Our Ref: EN010147

Application by Photovolt Development Partners (PVDP) on behalf of SolarFive Ltd for an Order Granting Development Consent for the Botley West Solar Farm

Advice following issue of decision to accept the application for examination

Title
**Operational Development Plan
Northern Site Area 2 of 2**

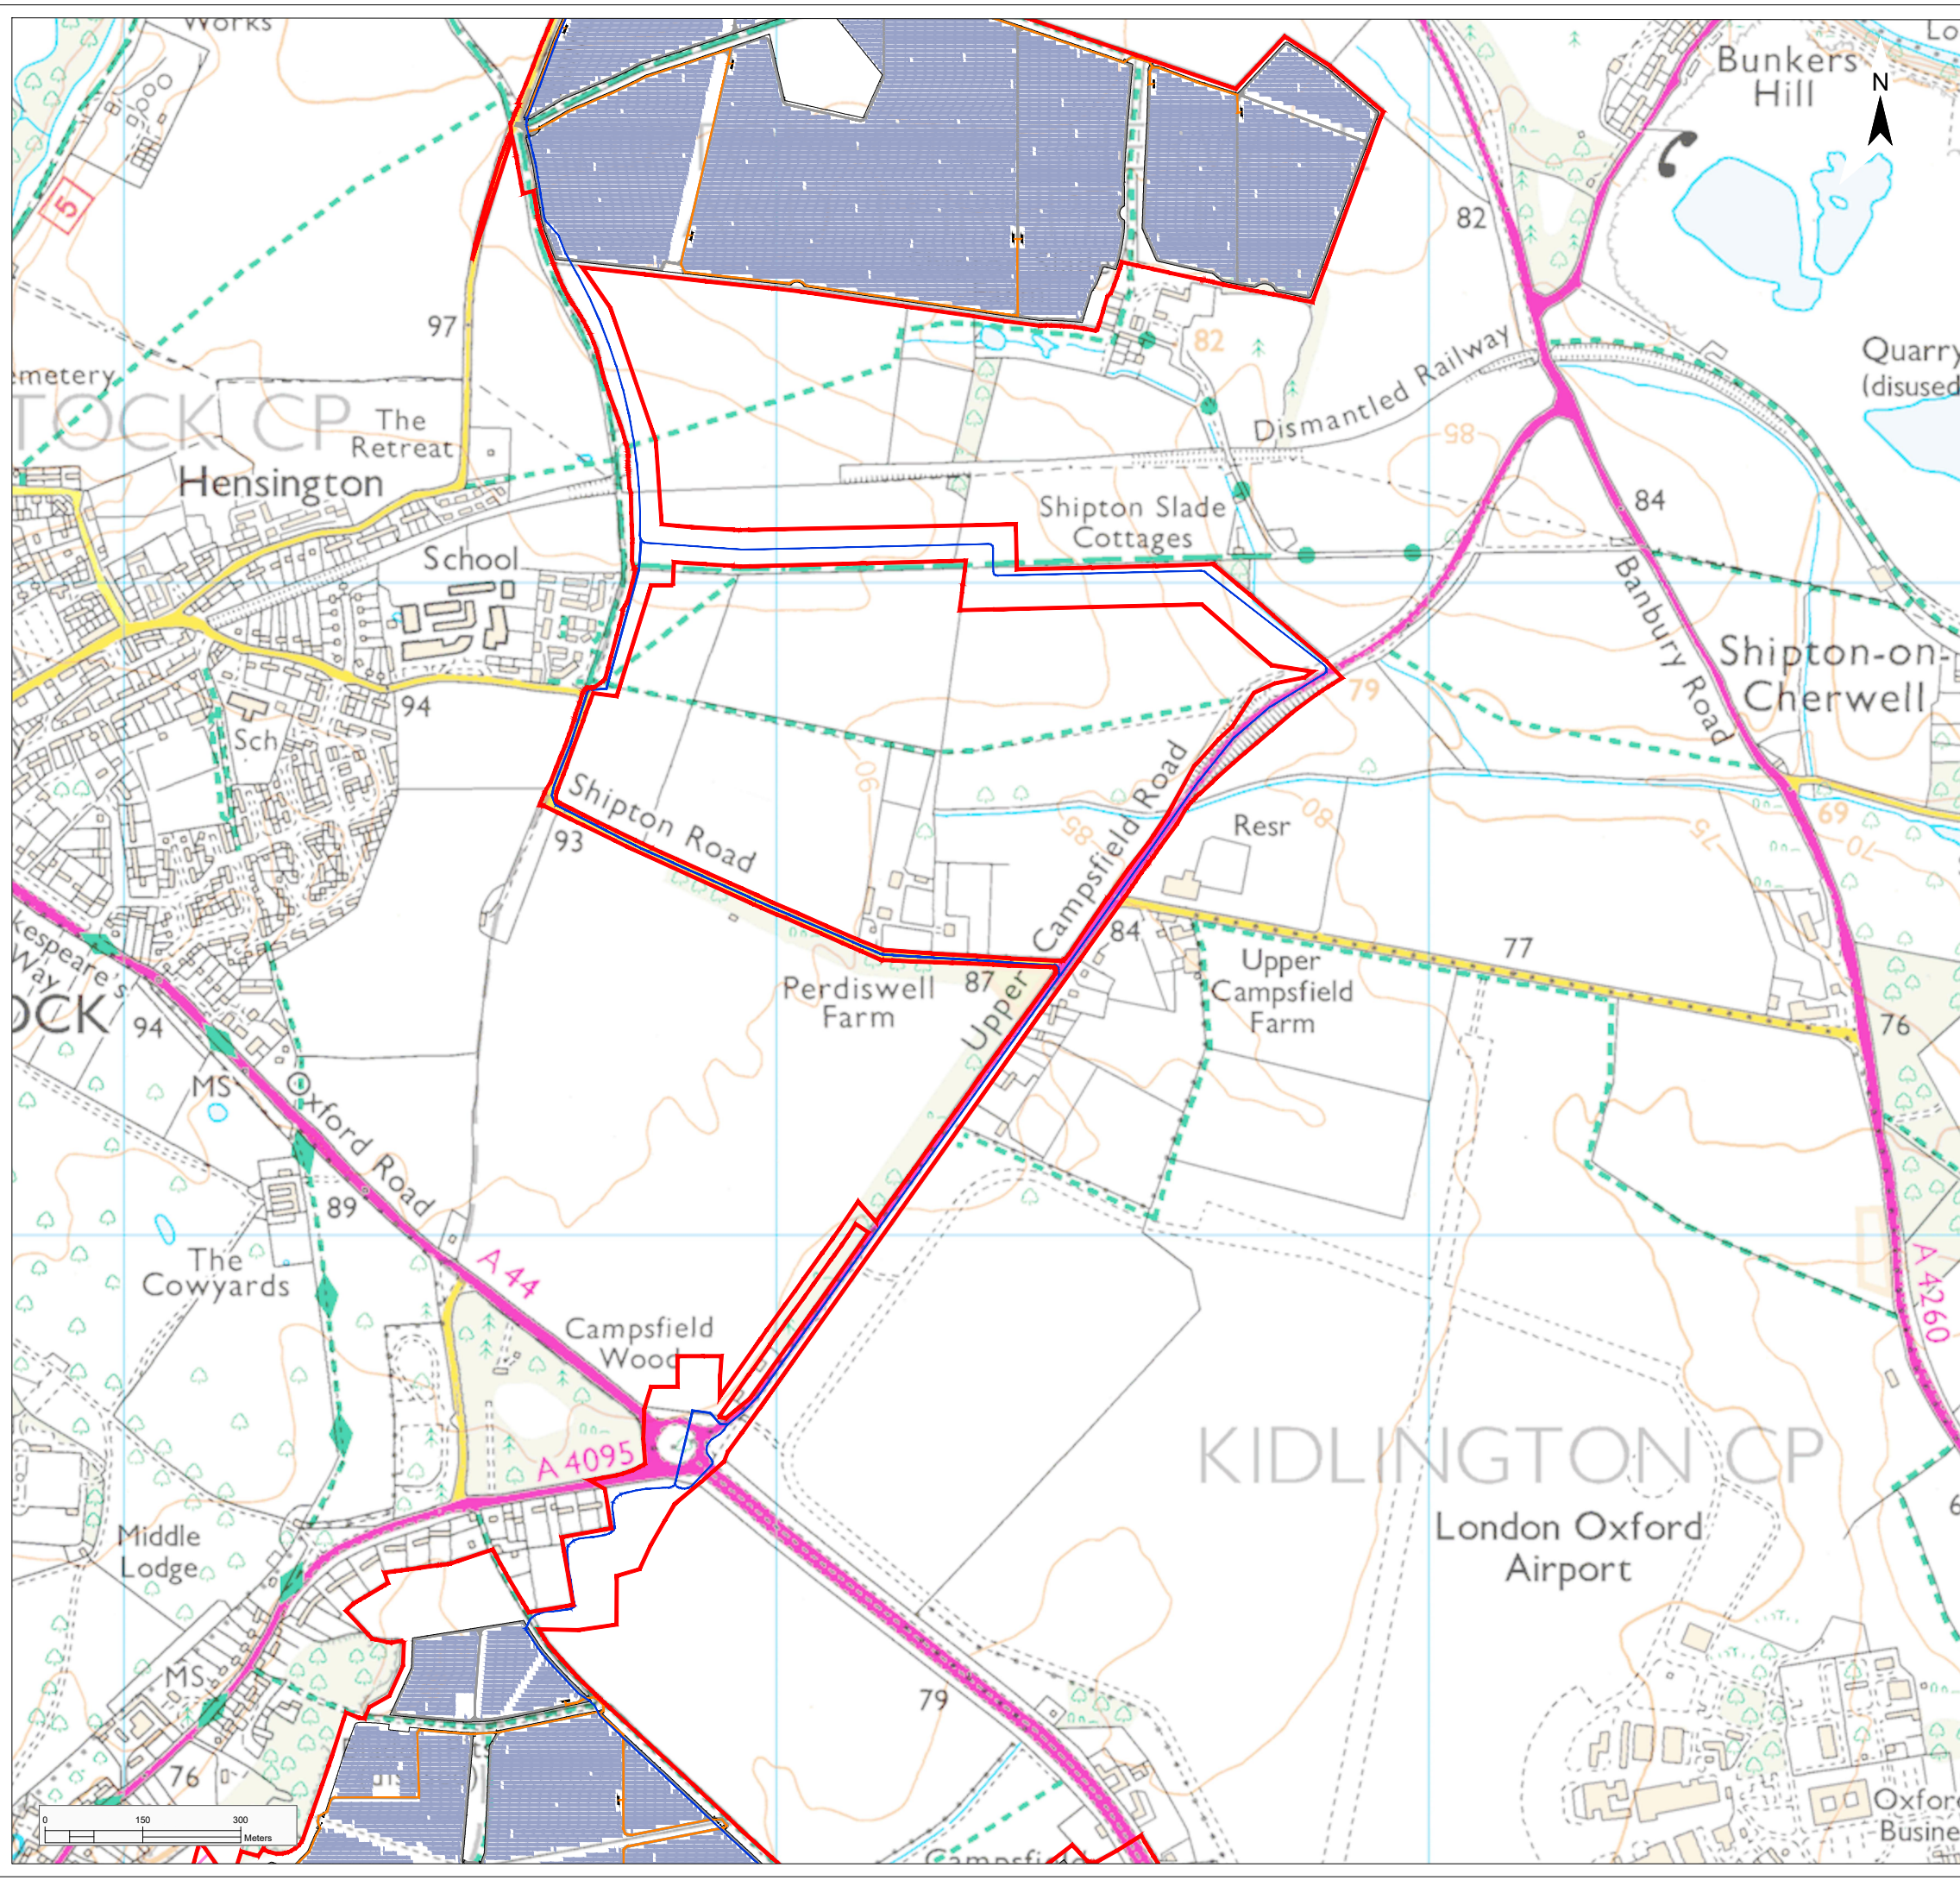
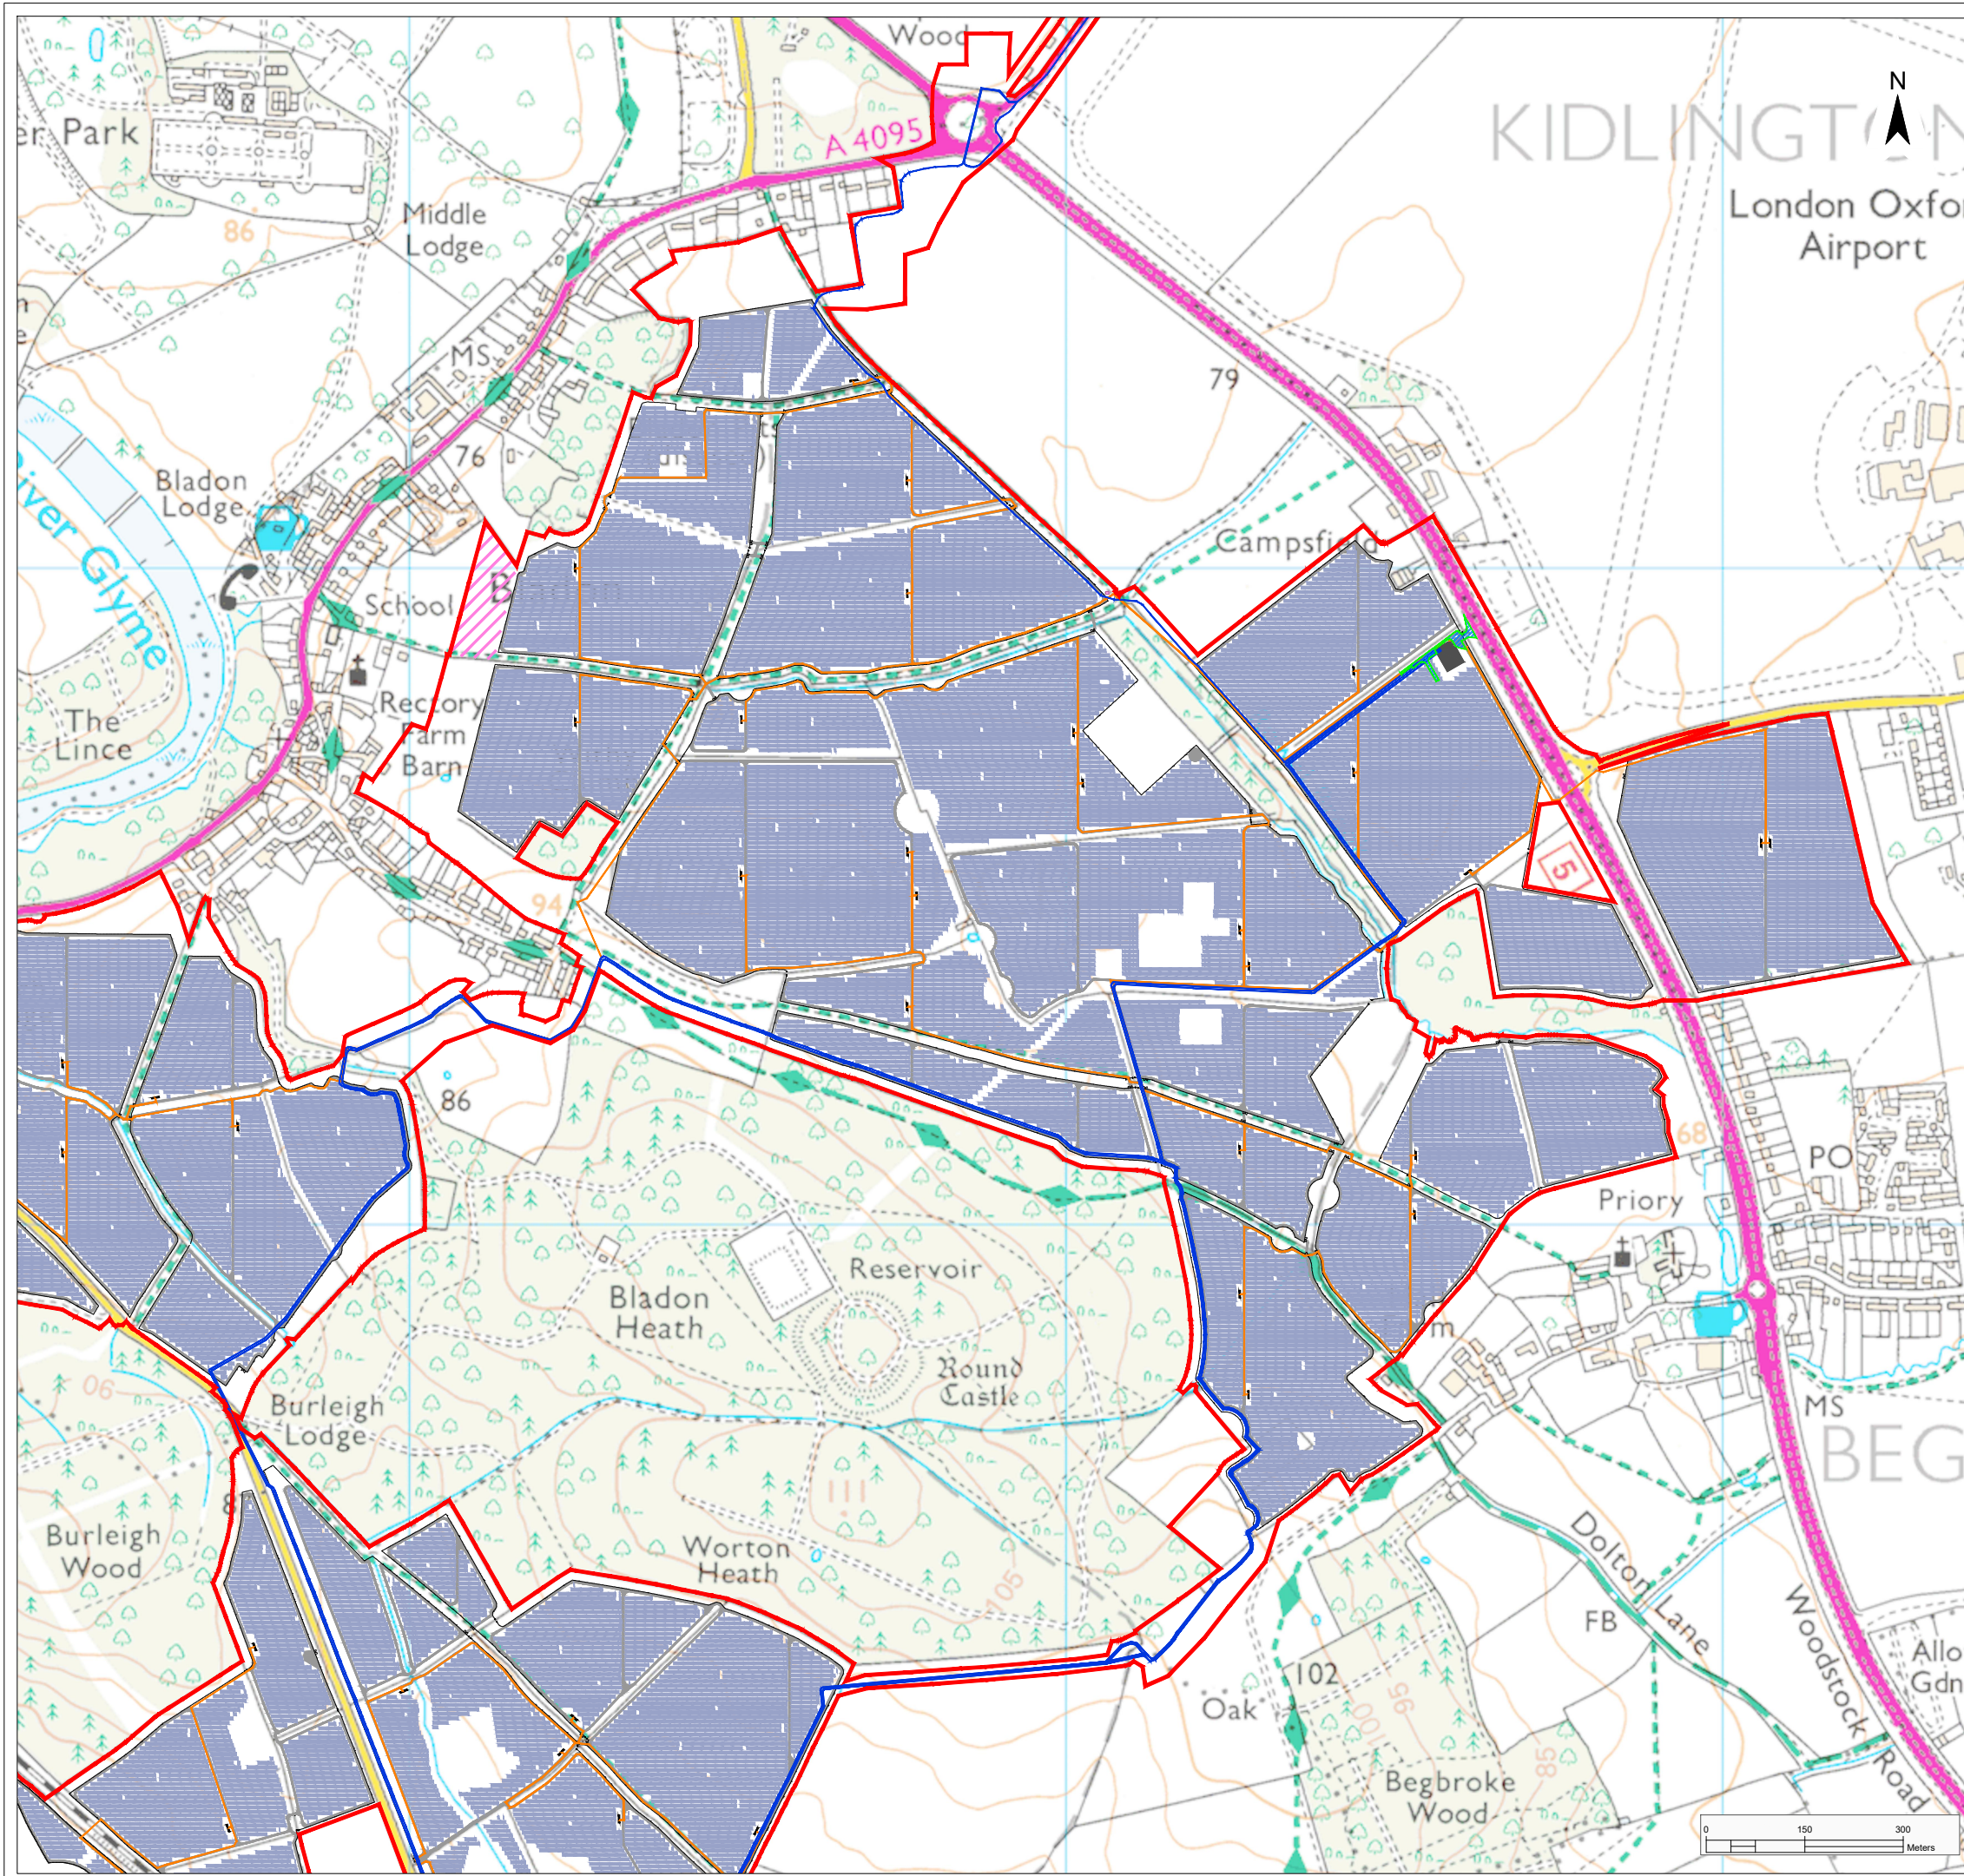
Operational Development Areas Plans (Doc 7.3.2), Landscape, Ecology & Amenities Layer Plan (Doc 7.3.3) and Temporary Facilities Plans (Doc 7.3.4)

The Inspectorate draws the attention of the applicant to APFP Regulation 5 (4A) in relation to these plan documents. The applicant may wish to amend these plans to ensure that the scale being used follows this regulation. For the benefit of the understanding of all parties to a future examination it may be desirable if it was more clearly presented on the plans which areas are within the Order Limits and how the sheet in question fits in the context of the wider site.
